**WEST SUSSEX COUNTY COUNCIL
PLANNING SERVICES CONSULTATION**

SUBJECT: AB/148/17/PL - To provide 4no. detached houses on existing semi natural woodland site.

Wooded Land South West of Dalloway Road, Arundel

RECOMMENDATION: Advice & More Information

1:500 Site Plan as proposed

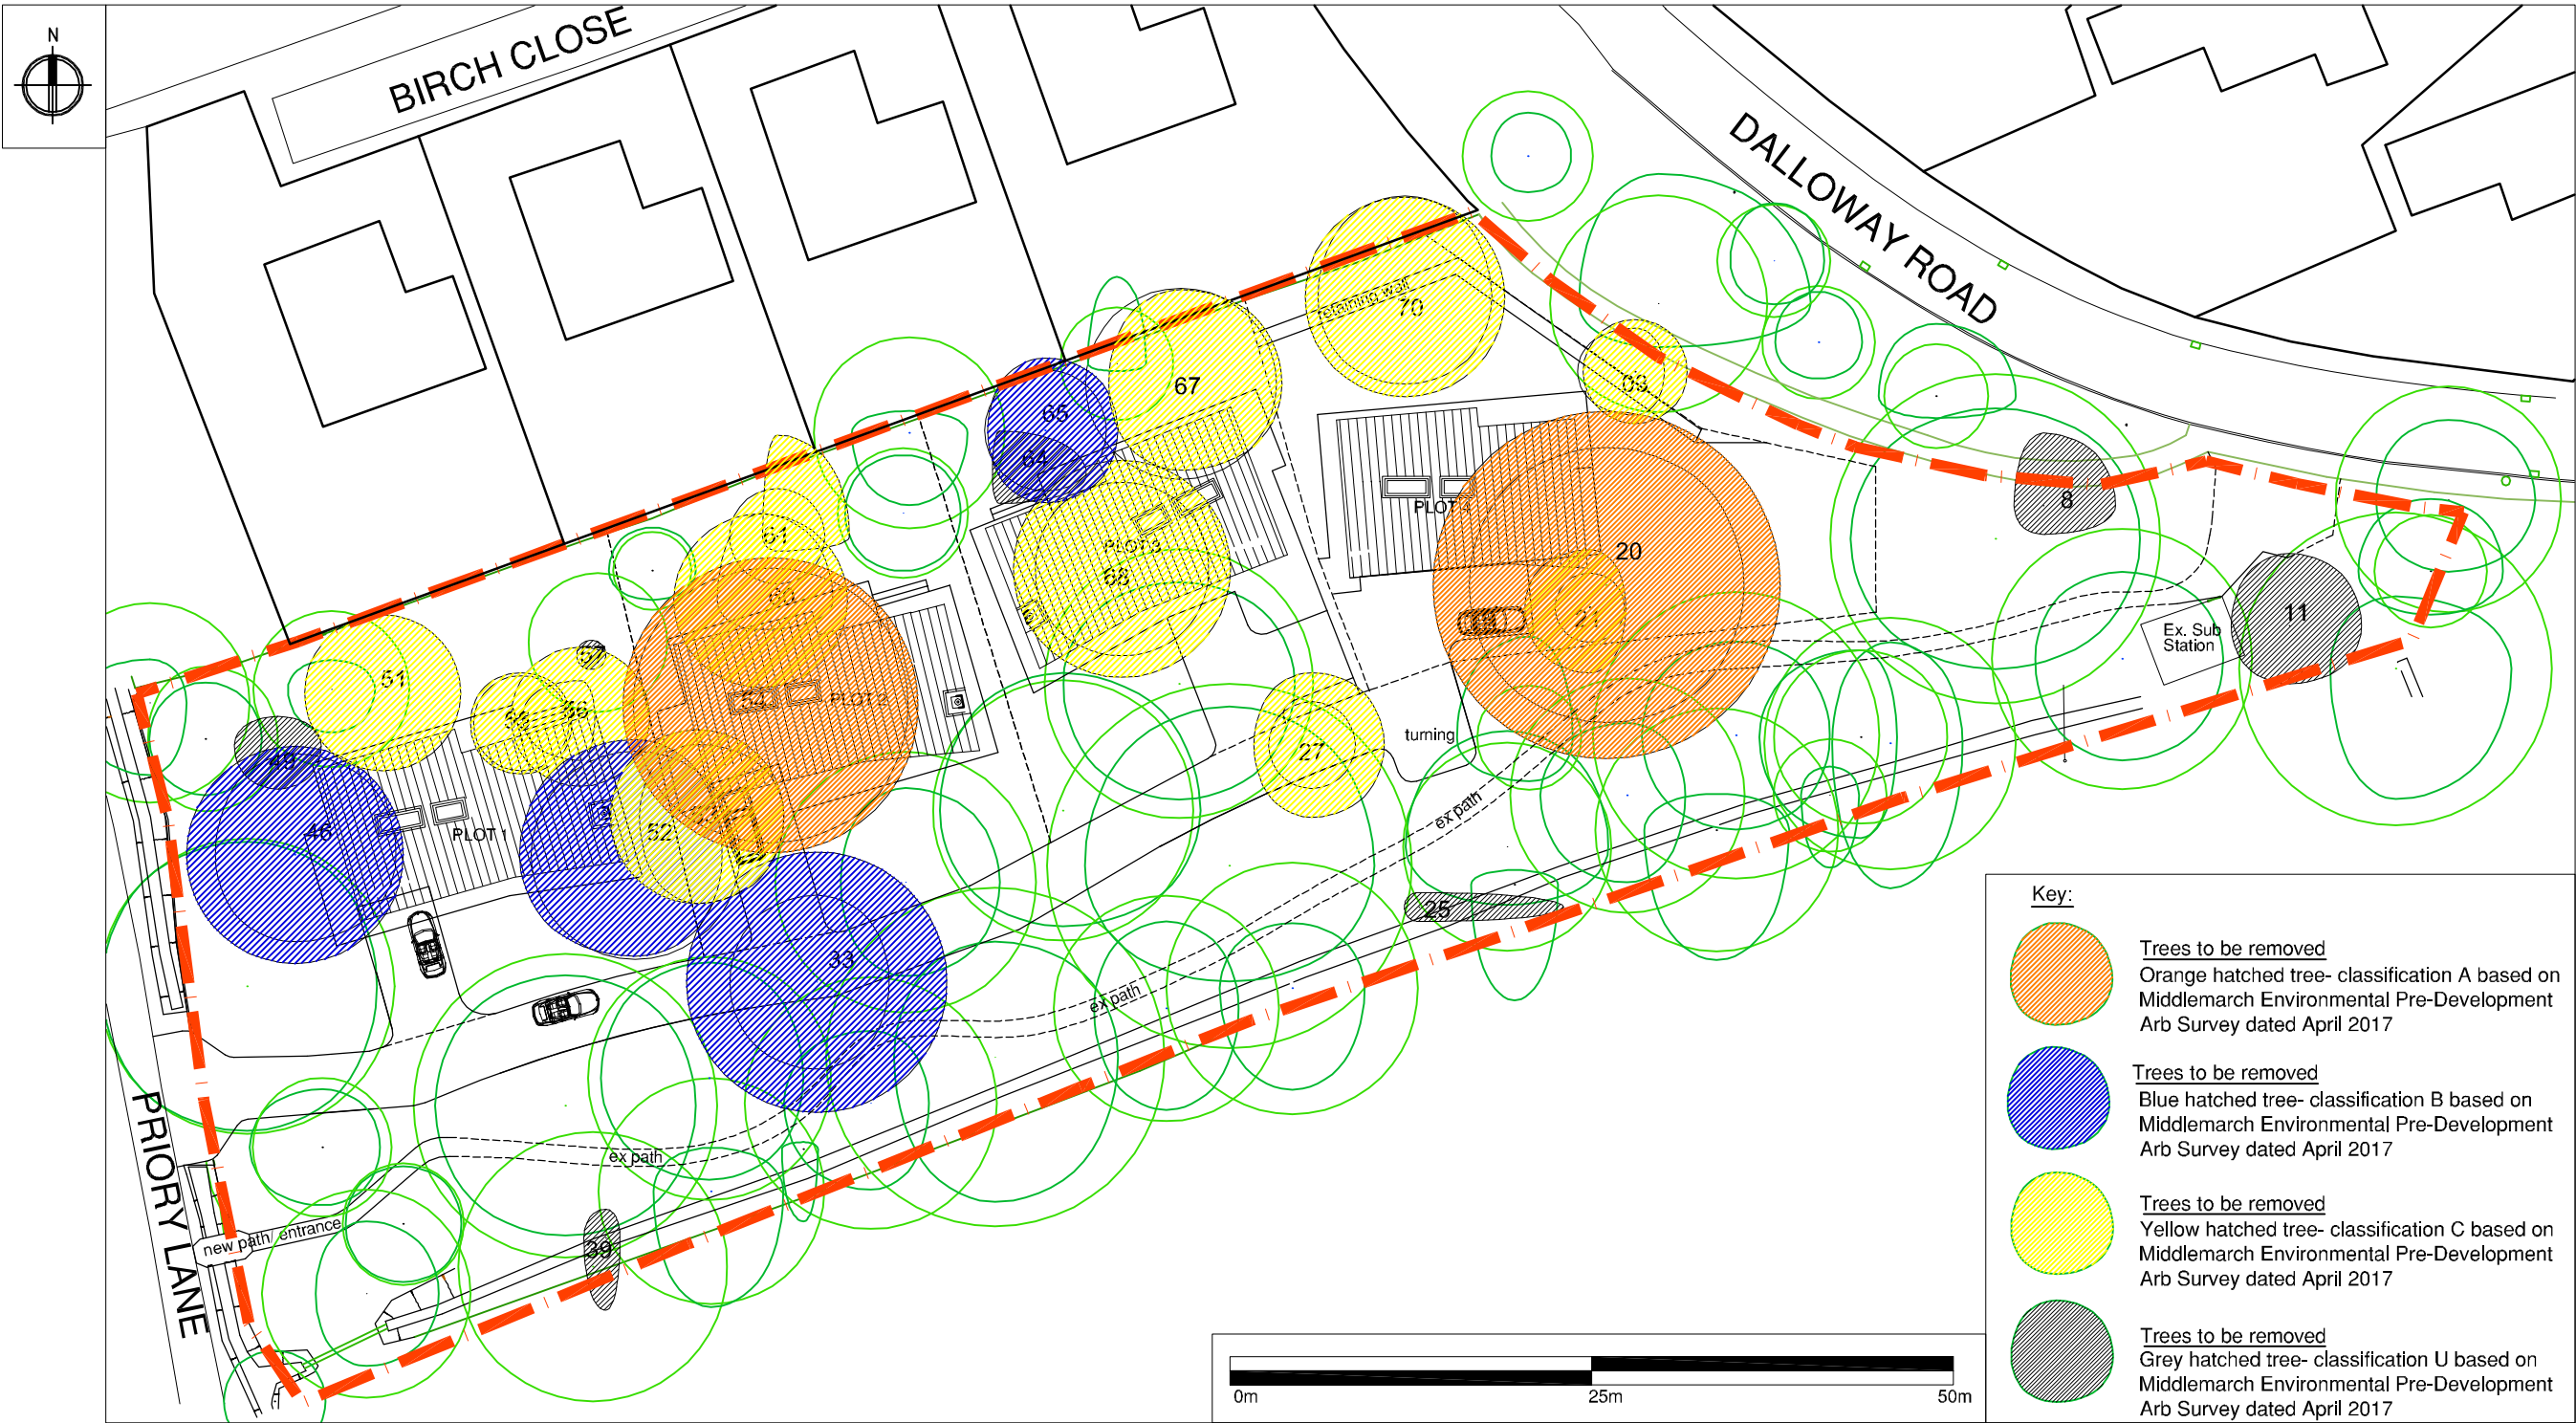
No visibility splay information has been provided by the applicant. Using WSCC mapping I would estimate that a visibility splay of 2.4 x 70 metres is available to the north and 2.4 x 55 metres is available to the south. Using the Manual for Streets methodology for calculating sight stopping distances these splays would equate to the sight stopping distances for vehicles approaching the site at 42 mph and 35mph respectively.

Notwithstanding the above the applicant should demonstrate that safe and suitable access can be achieved into the site. The applicant should therefore provide a plan demonstrating the maximum achievable visibility splays at the site access point. These splays shall be contained wholly within land under control of the applicant or that considered public highway.

Priory Lane is narrow in nature and the applicant has not demonstrated if it would be achievable for a fire tender to access the site using the proposed access arrangements via swept path tracking.

The site lay out provided does not provide the opportunity for a fire tender to turn on site.

As per advice provided within Manual for Streets Paragraph 6.8.9 there is a building regulation requirement that residents should not be required to carry waste more than 30 m to a storage point. Waste collection vehicles should be able to get to within 25 m of the storage point. The layout of the site may therefore require a refuse vehicle to enter the site; a turn on site for a refuse vehicle may then be required.

Neither of these matters has been satisfactorily demonstrated with the plans provided. I would as the applicant consider the above matters and provide additional details in including swept path tracking where necessary.

Each dwelling will be provided an off street hardstanding parking area large enough to accommodate at least two vehicles. On this basis an additional unallocated visitor car parking spaces would be required meet the anticipated demand of the development. While it is appreciated some of the proposed hardstanding areas are large enough to accommodate additional car parking this would not be available on an unallocated basis. I would advise one unallocated visitor space is provided and would accept such a matter could be secured via planning condition.
